SUBJECT: Engineering Review Comment
Mountain View Electric Association Inc. (The Association)

Project Name: Warner Minor Subdivision

Project Number: MS214

Description: Proposed development of 4 single family lots on 40 acres located at 17350 Goshawk Rd. in Township 11, Range 65, Section 23.

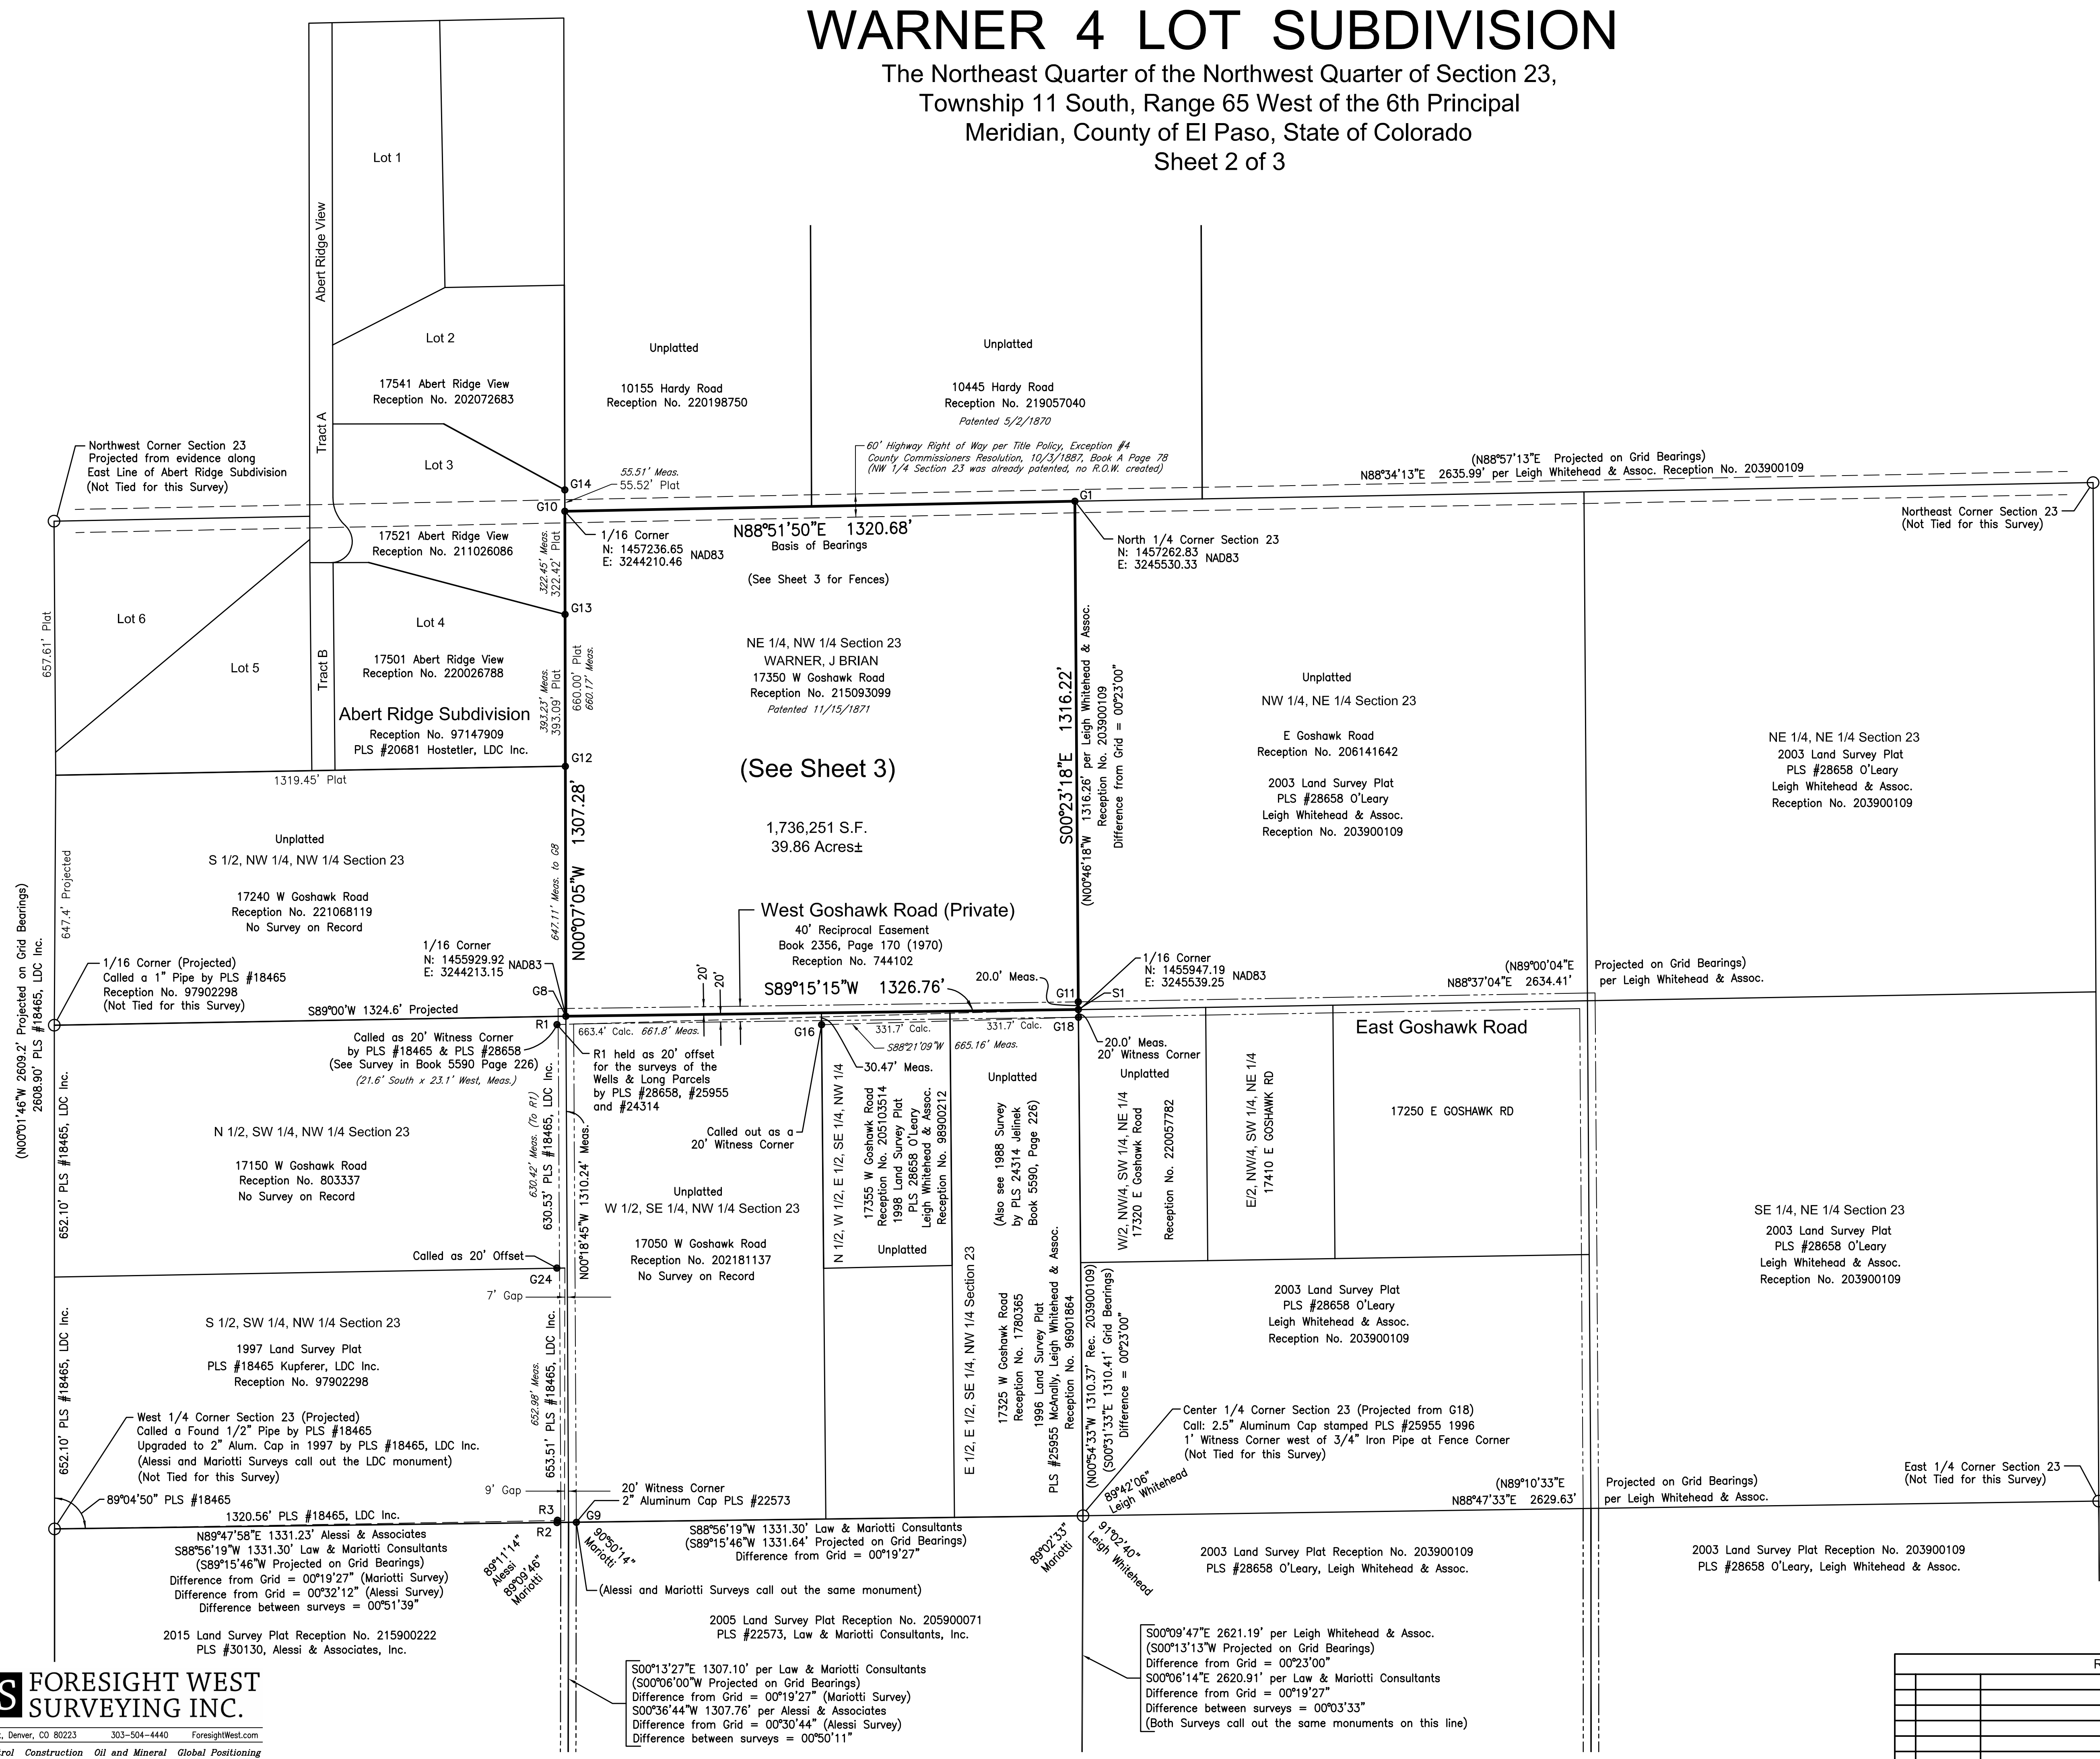
The Association requests a ten (10) foot front, side, and rear lot utility easement and all tracts, along with a twenty (20) foot exterior utility easement on the plat. The Association also requests the platting of the Association's existing facilities with easements on the plat. Additional easements may be required.
